**Application by North Somerset District Council for an Order granting  
Development Consent for the Portishead branch line – MetroWest Phase 1**

**Issue Specific Hearing 2, Day 1, Monday 11 January 2021**

**Response to Action Points**

**Agenda item 4 - Permanent Public Right of Way Diversions and Alternatives**

**ROYAL PORTBURY DOCK ROAD
EQUESTRIAN UNCONTROLLED
CROSSING**

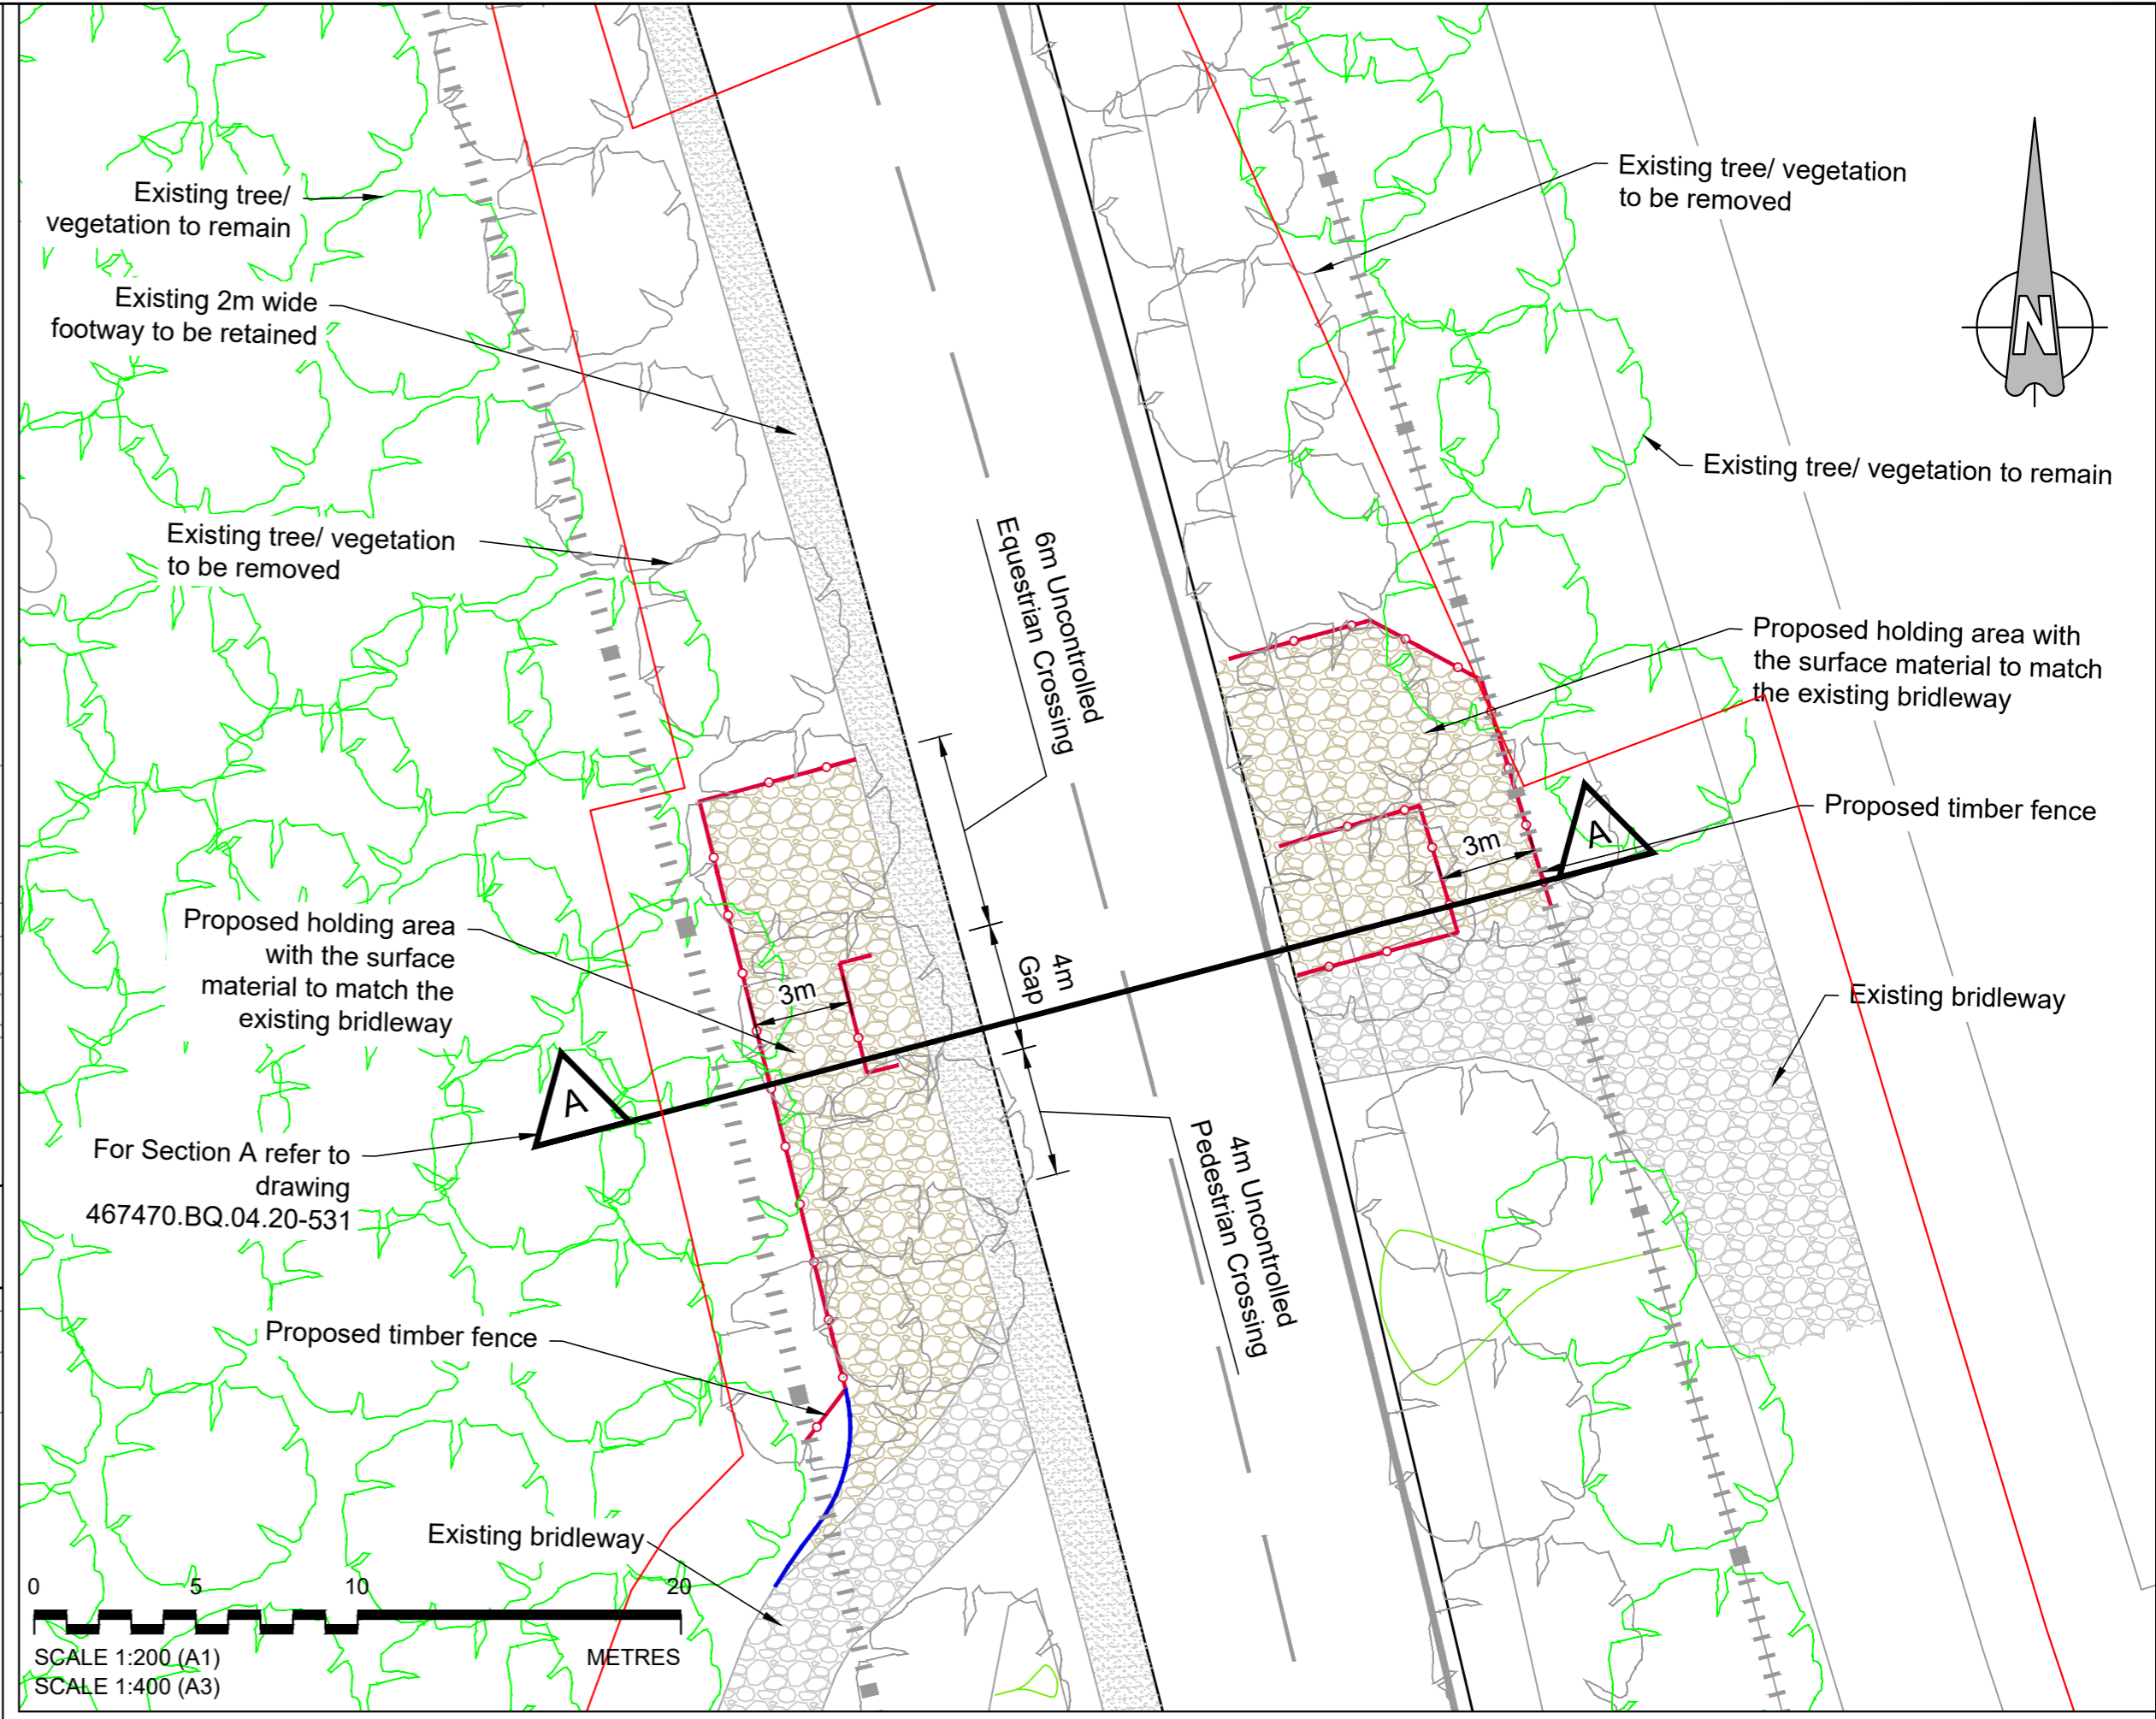
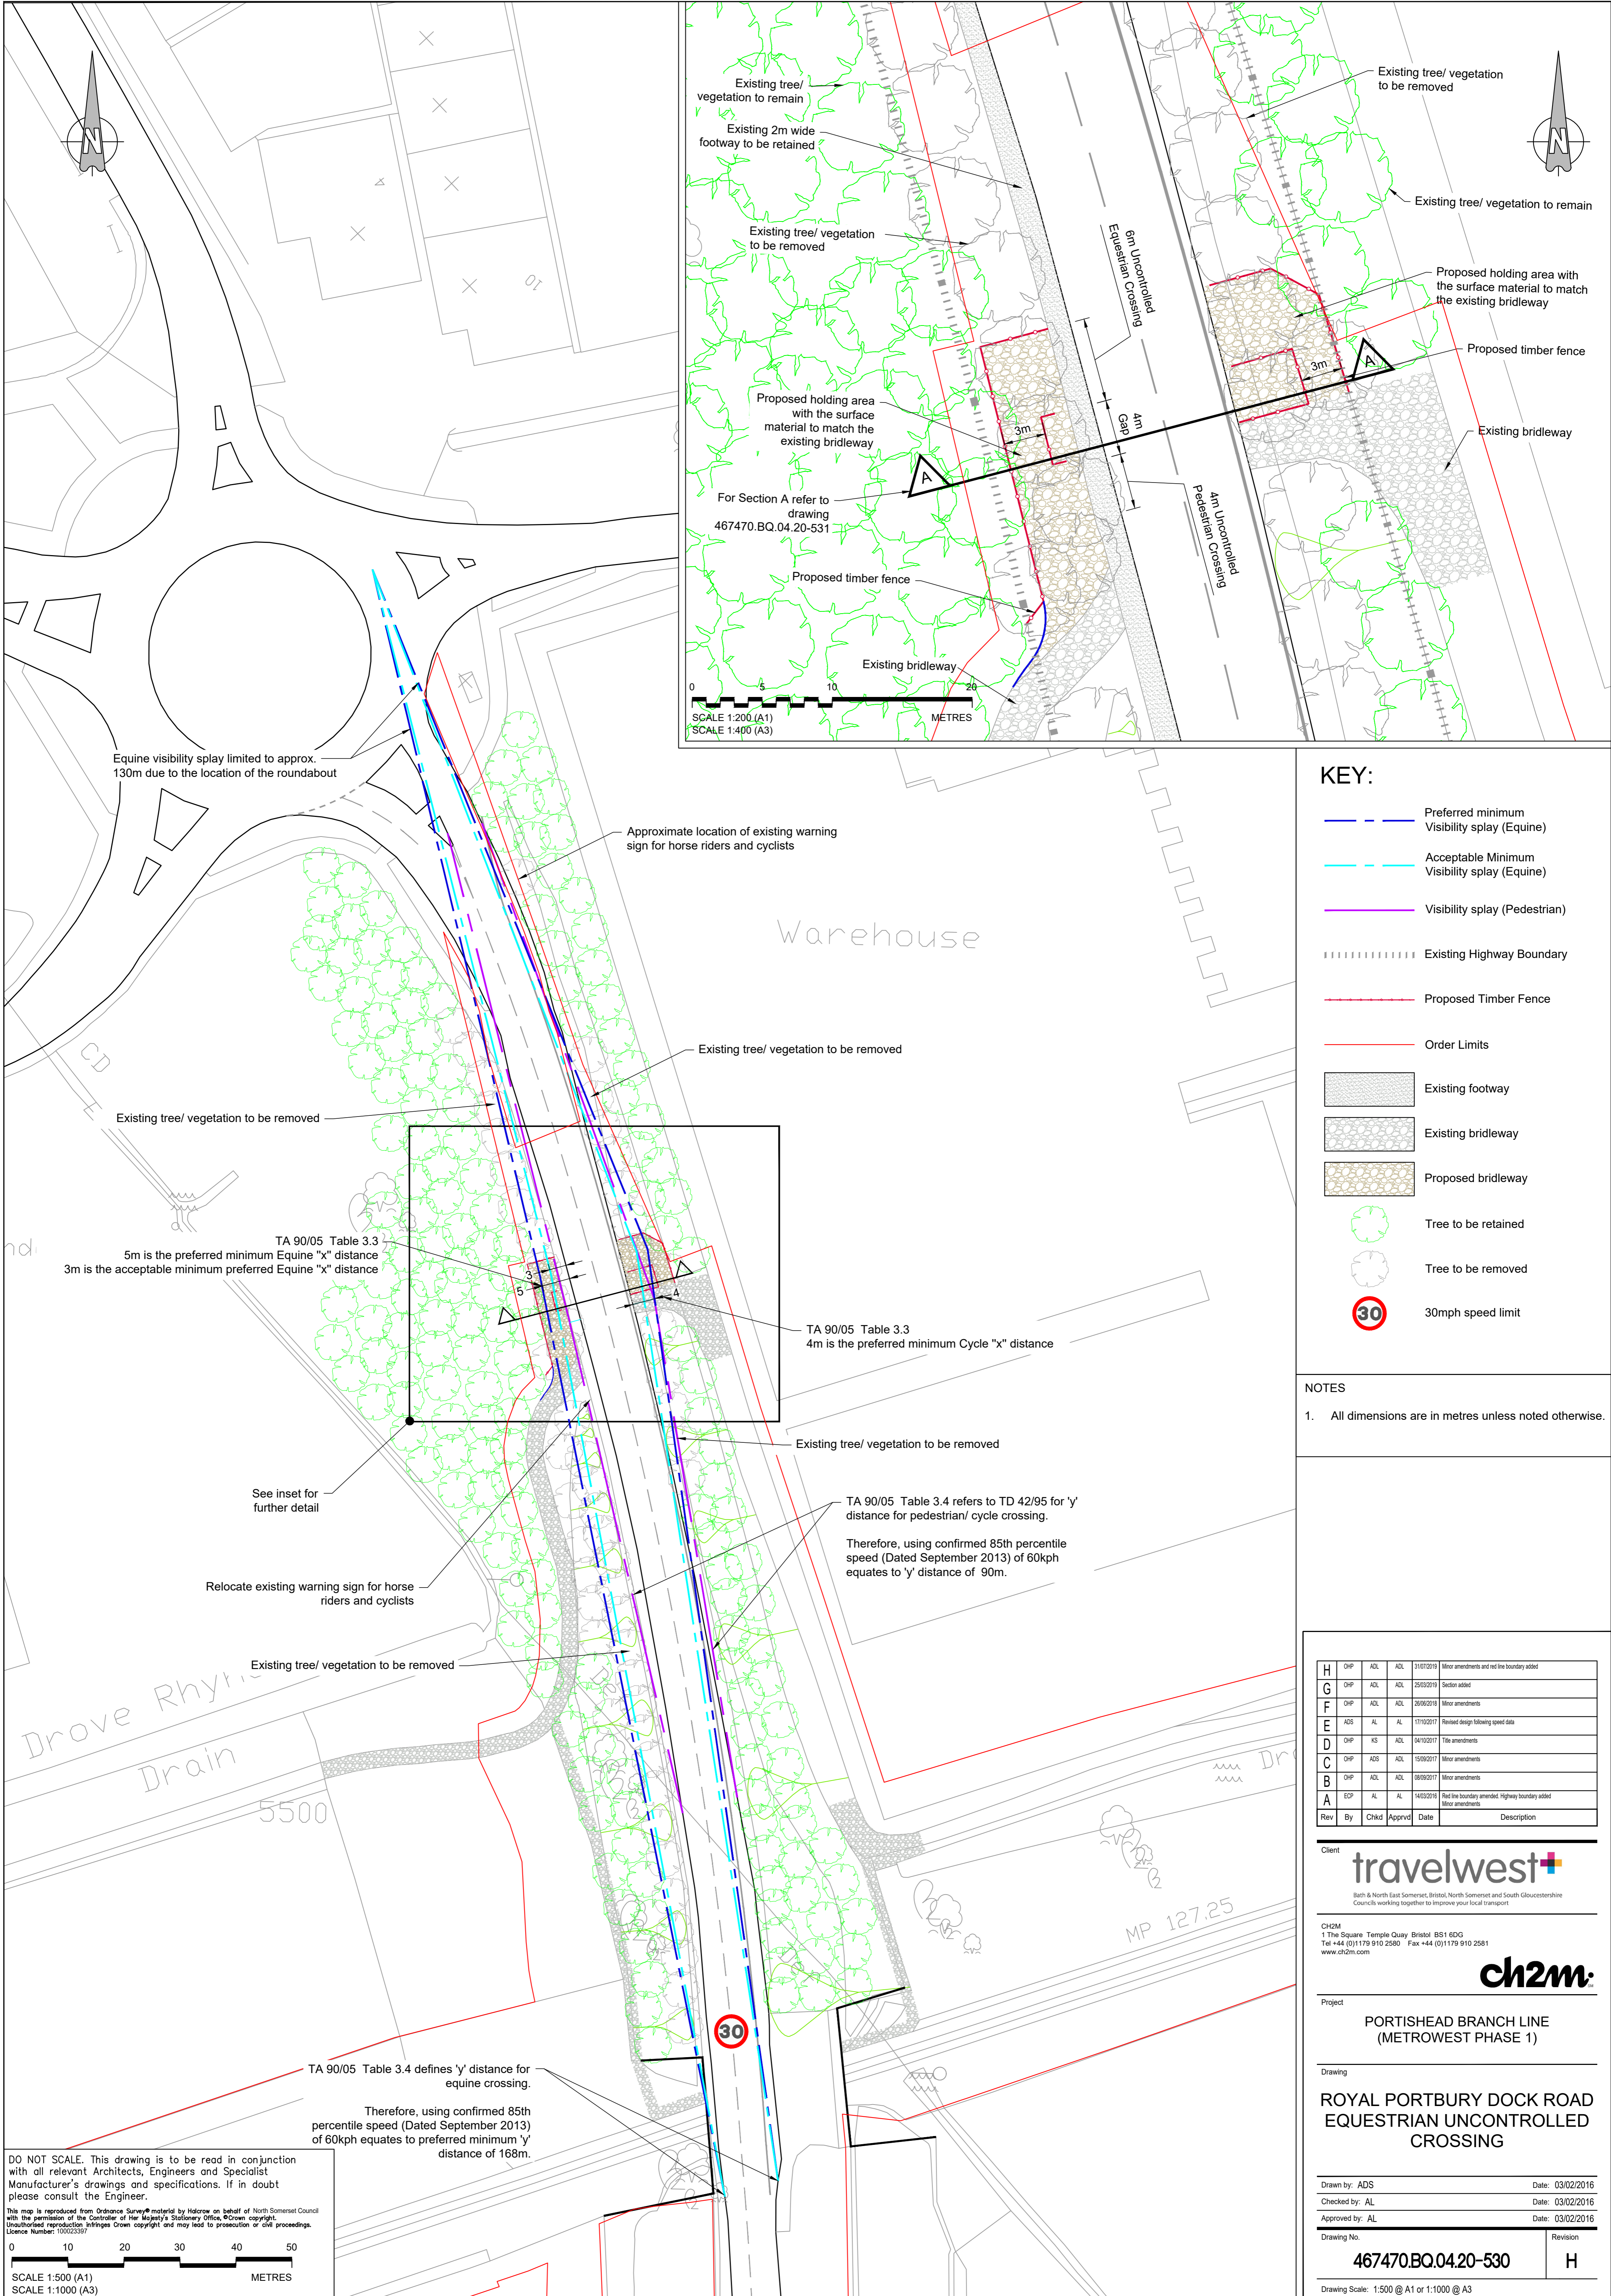
1. Bridleway Crossing Royal Portbury Dock Road. Works 14, 14A, 14B.  
LA15/66/10, LA15/21/20, LA8/66/10

I spoke raising my concerns about the bridleway crossing at Portbury Dock Road.

I stated that the speed limit was 50 mph, it is actually 30 mph.

I regularly use this route (approx. 5 days a week in both directions) and often cross at Royal Portbury Road if I do not use the underbridge option. I note that vehicles frequently appear to travel in excess of the speed limit on what is a straight and very wide road; with sometimes continuous, fast moving streams of HGV's, lighter commercial traffic and cars, particularly in peak periods.

I have never seen any horses/ horse riders, and rarely other users on either part this bridleway as it crosses Royal Portbury Dock Road; they, like the majority of traffic using the cycle path, choose to take the safer underbridge route.

The cycle path/ bridleway is becoming increasingly busy with horse riders, walkers, runners and cyclists; the latter of which can be individuals, or groups of varying sizes often multiple family groups including children of all ages.

Therefore, I share the view that providing an uncontrolled crossing on this road could potentially result in a serious accident. Crossing on a horse would be extremely dangerous. Crossing on foot or cycle is already hazardous.

I understand that there is an objective to provide a route for horses that avoids the need to pass under the Portbury Dock Road overbridge close to the reinstated rail track. However, unless user controlled traffic lights are provided for the crossing, I believe that it would be extremely dangerous to encourage horse riders, pedestrians and cyclists to cross the road at this location. This applies both when the underbridge is closed off during the construction period and post construction when the underbridge is hopefully reopened.
